SSD 7317 MODIFICATION 3 – RESPONSE TO SUBMISSIONS

This Response to Submissions report (RTS) is submitted to the (the Department) in support of Modification 3 to amend State Significant Development (SSD) consent SSD – 7317 relating to the construction of a commercial campus at the Australian Technology Park, Eveleigh.

3 URBAN FARM KITCHEN - ELEVATION B
1 : 25

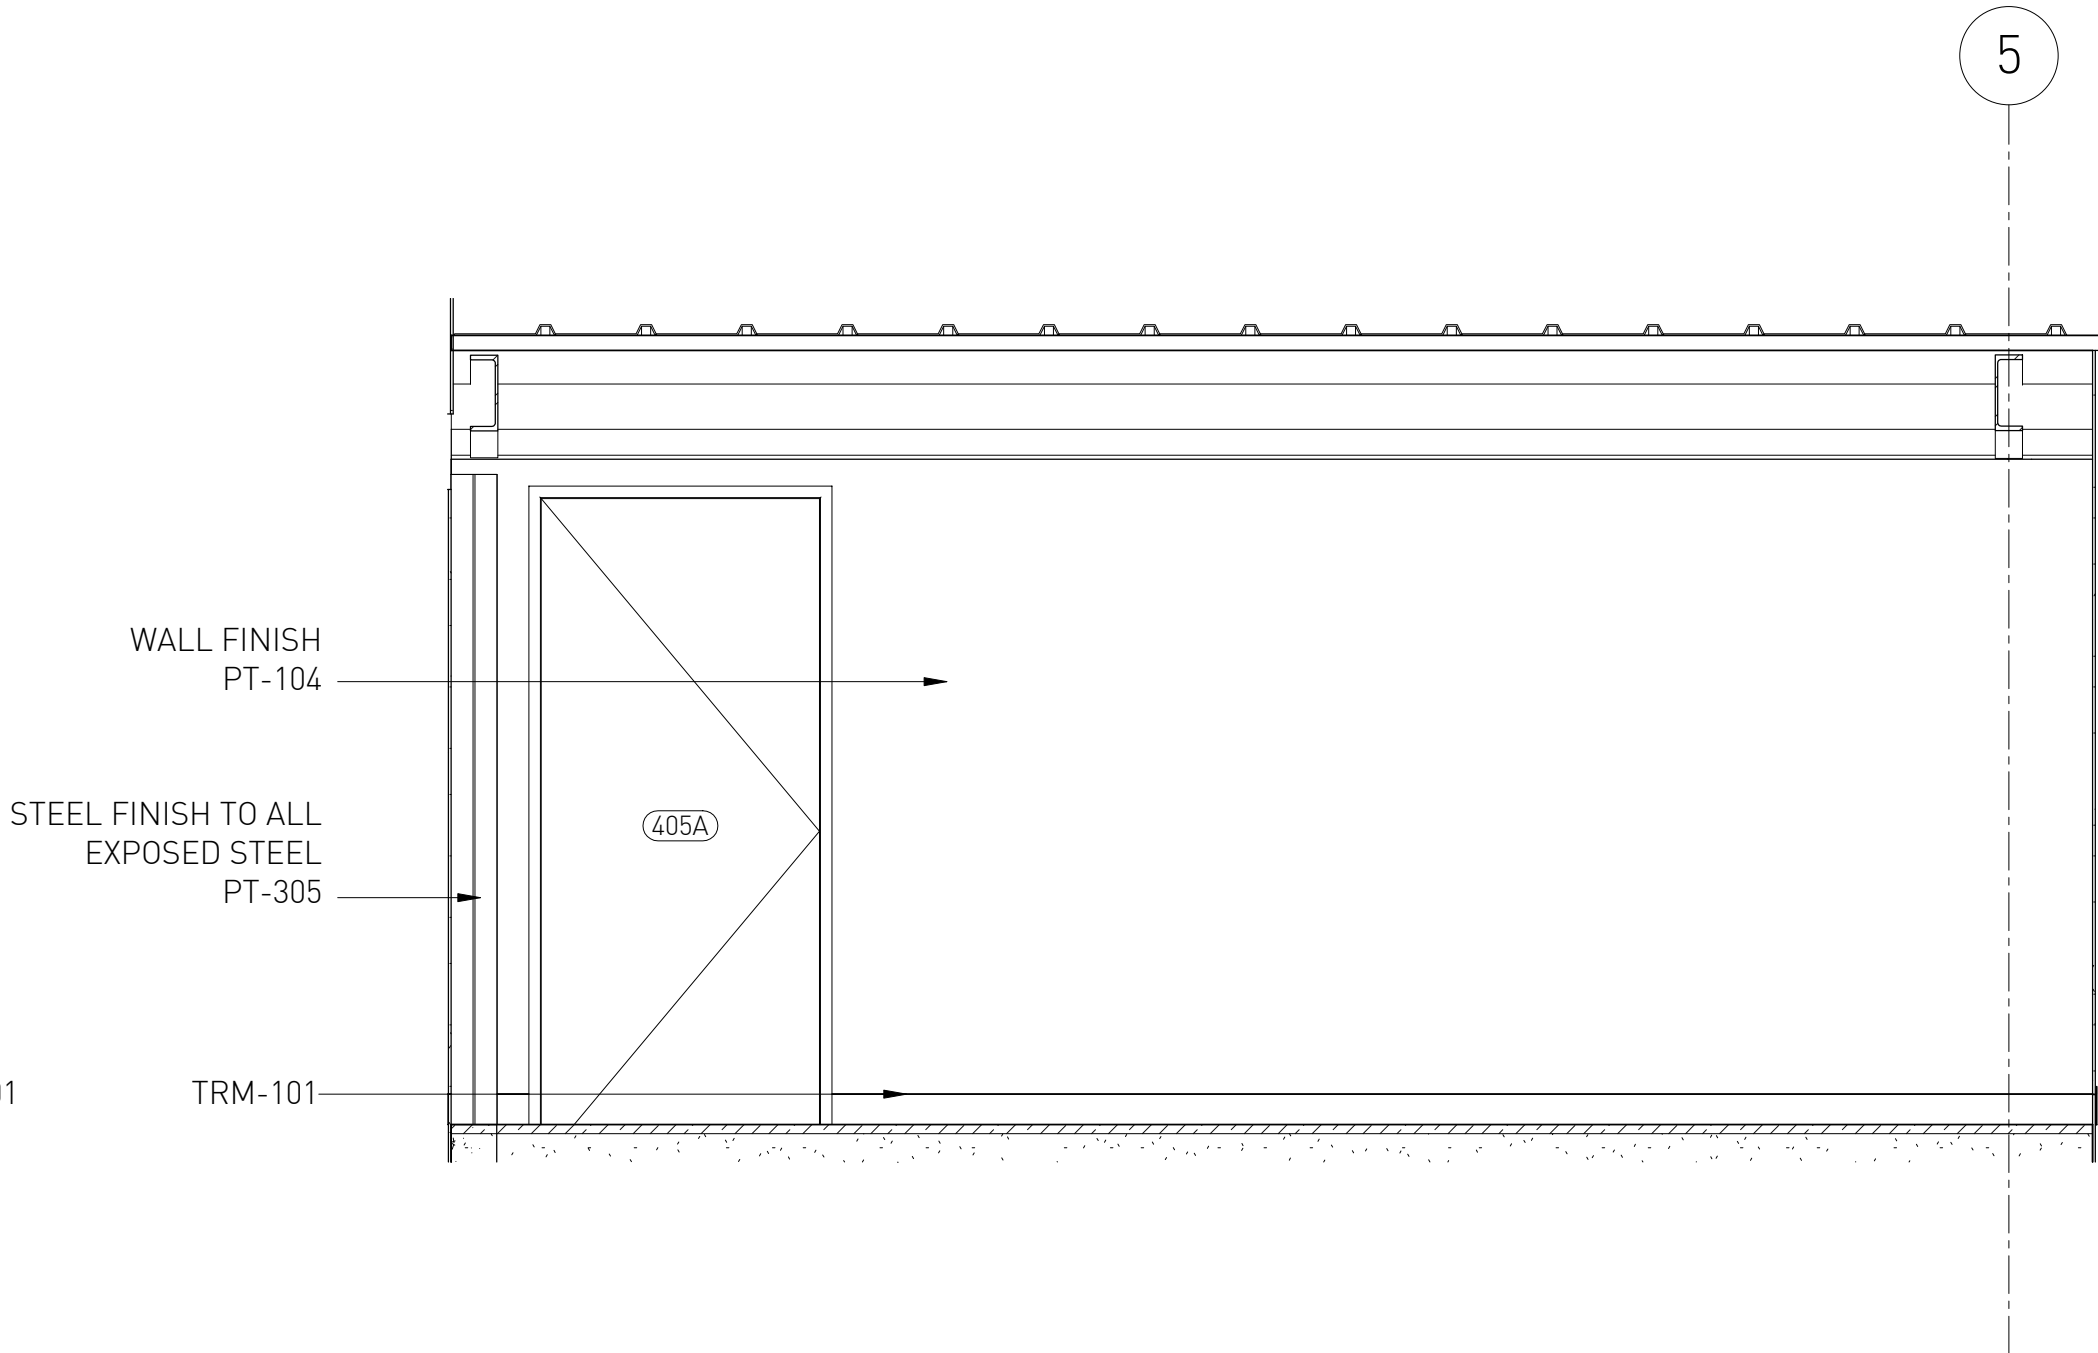
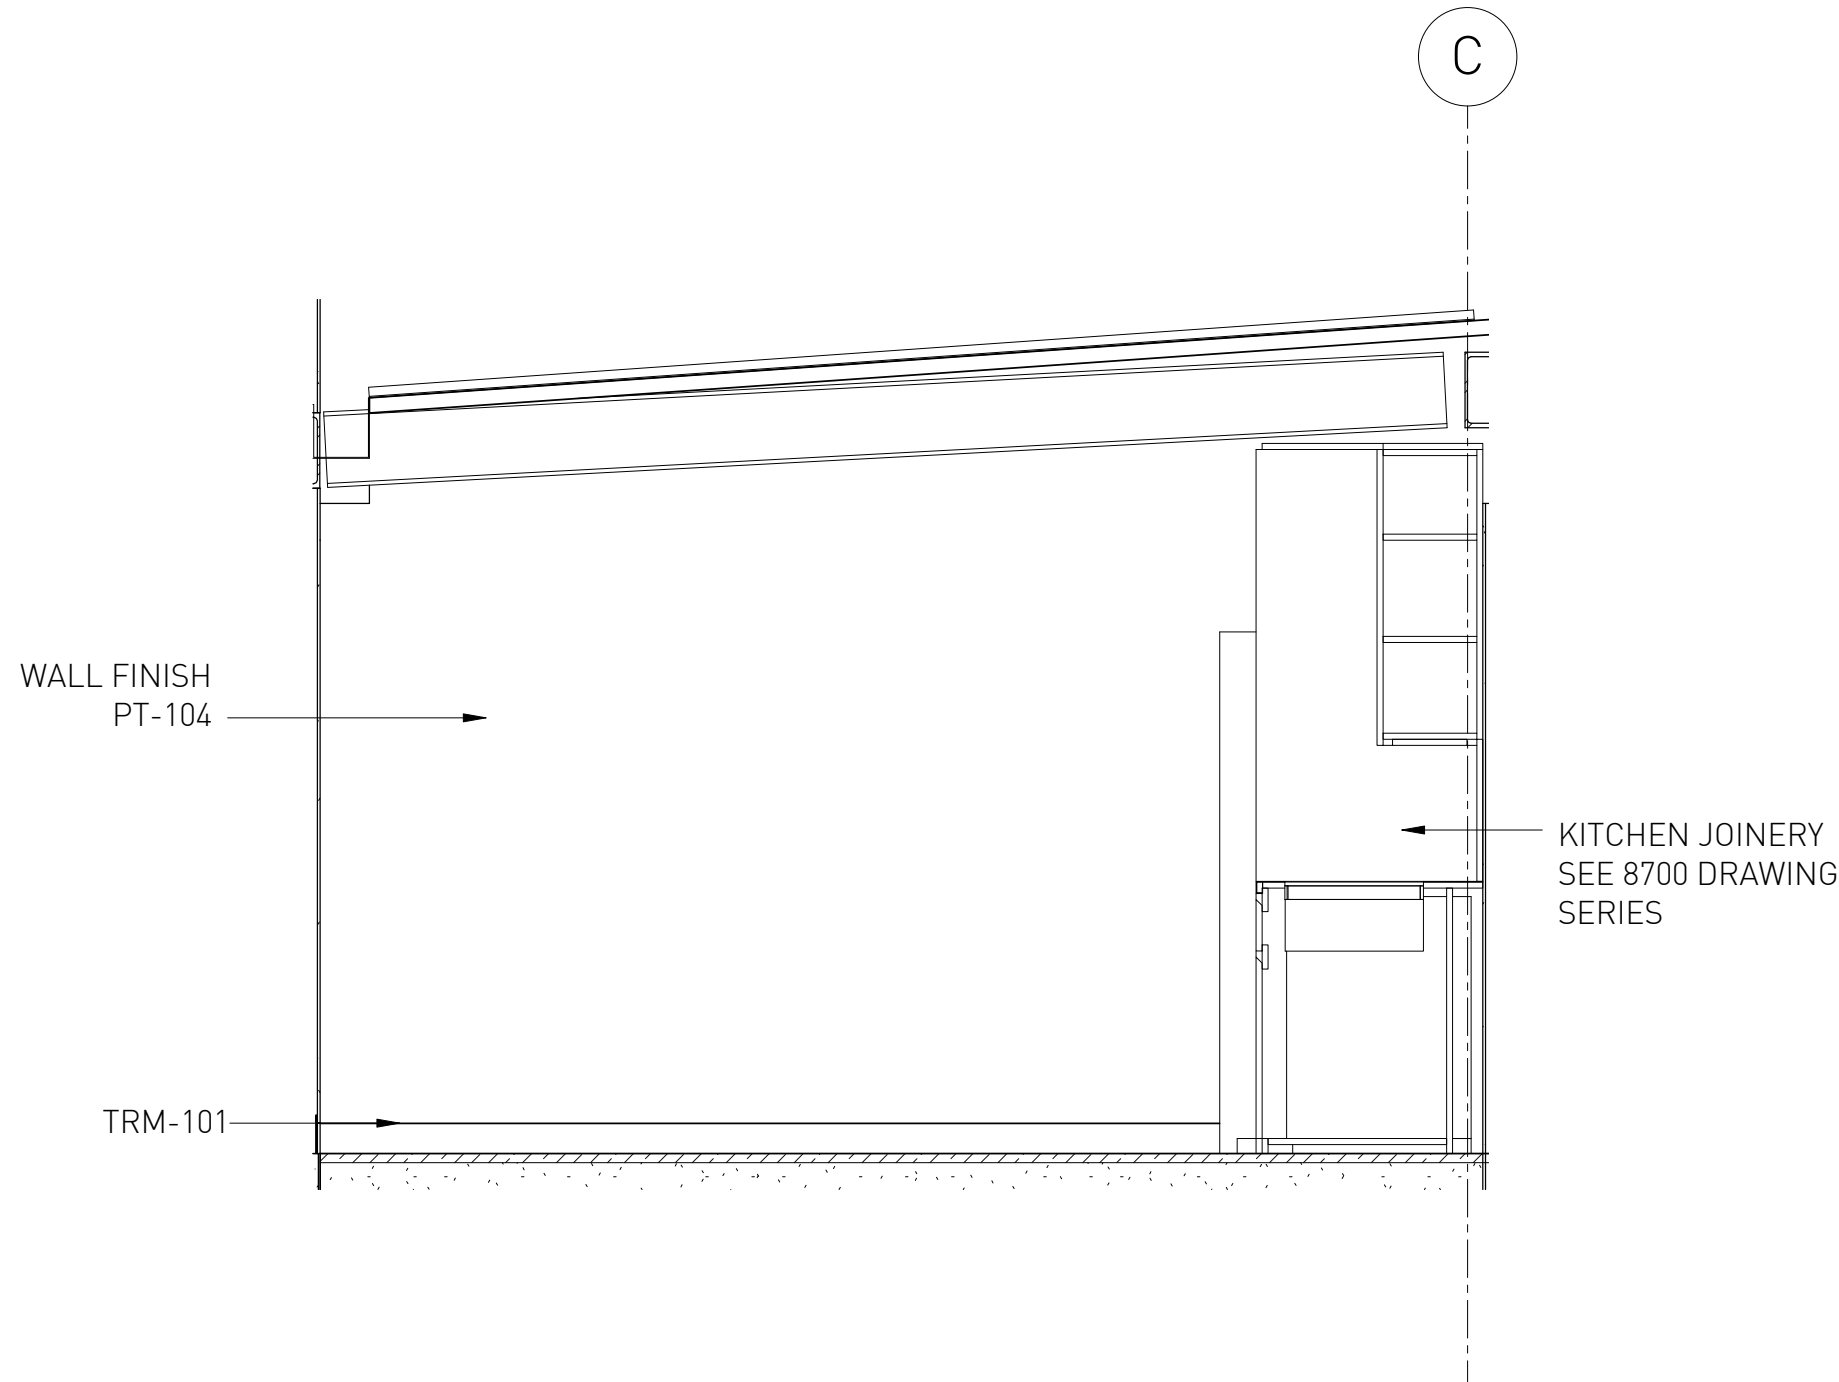
It is also noted that a rooftop kitchen is proposed. It is unclear what the purpose of the kitchen is and if food for sale (as defined by the Food Act 2003) is intended to be prepared there. If food for sale is prepared, the design and use of the kitchen must comply with the requirements the Food Act 2003

The rooftop kitchen is purely a reheat facility to allow the farm operator to facilitate small gatherings / events on the roof in association with the farm. It will not be used to prepare food for sale.

1 URBAN FARM KITCHEN - ELEVATION A - JOINERY
1 : 10

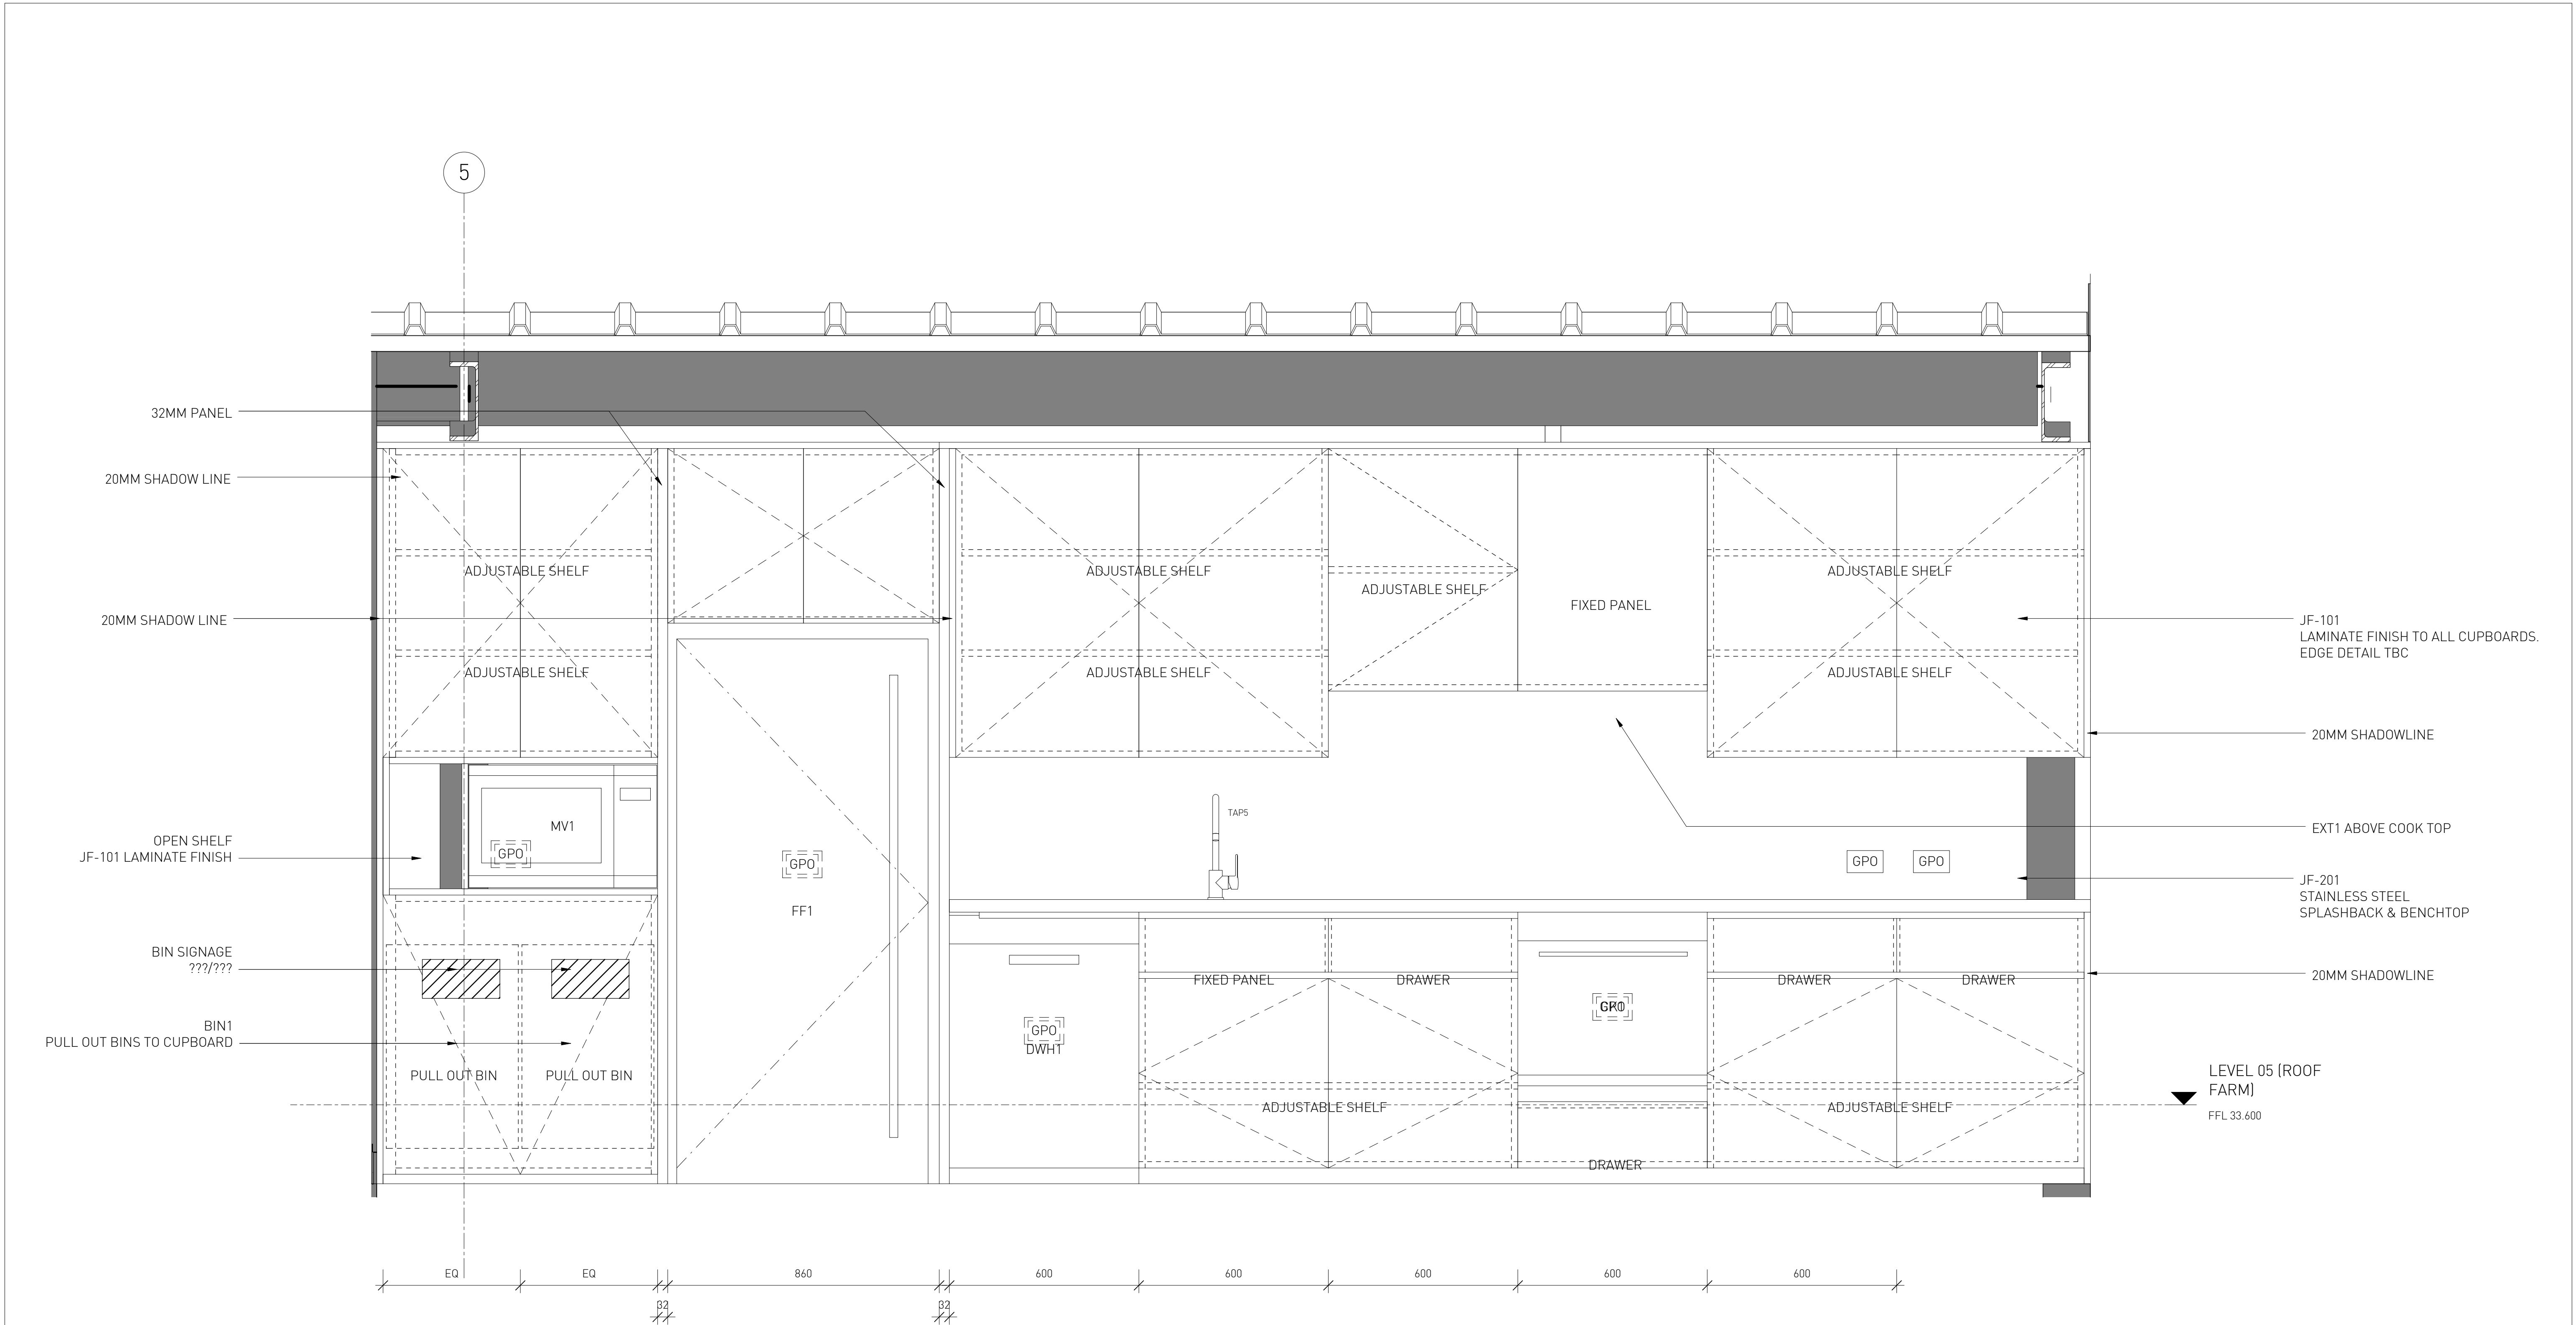
For example, the drawings indicate that the large roof planter will be 500mm higher than the adjacent FFL. Given the intended soil depth is likely to be insufficient to support tree planting, no information has been submitted which demonstrates exactly how the area will function. It is recommended that a more detailed design and package of information is submitted to assist with the assessment, which addresses use of the area including:

- *a detailed section through the planter, showing soil depth, drainage cells, waterproofing and the like;*

Please refer to Floor Type EFL-107 (Drawing 5510) which provides proposed build-up of roof top planters.
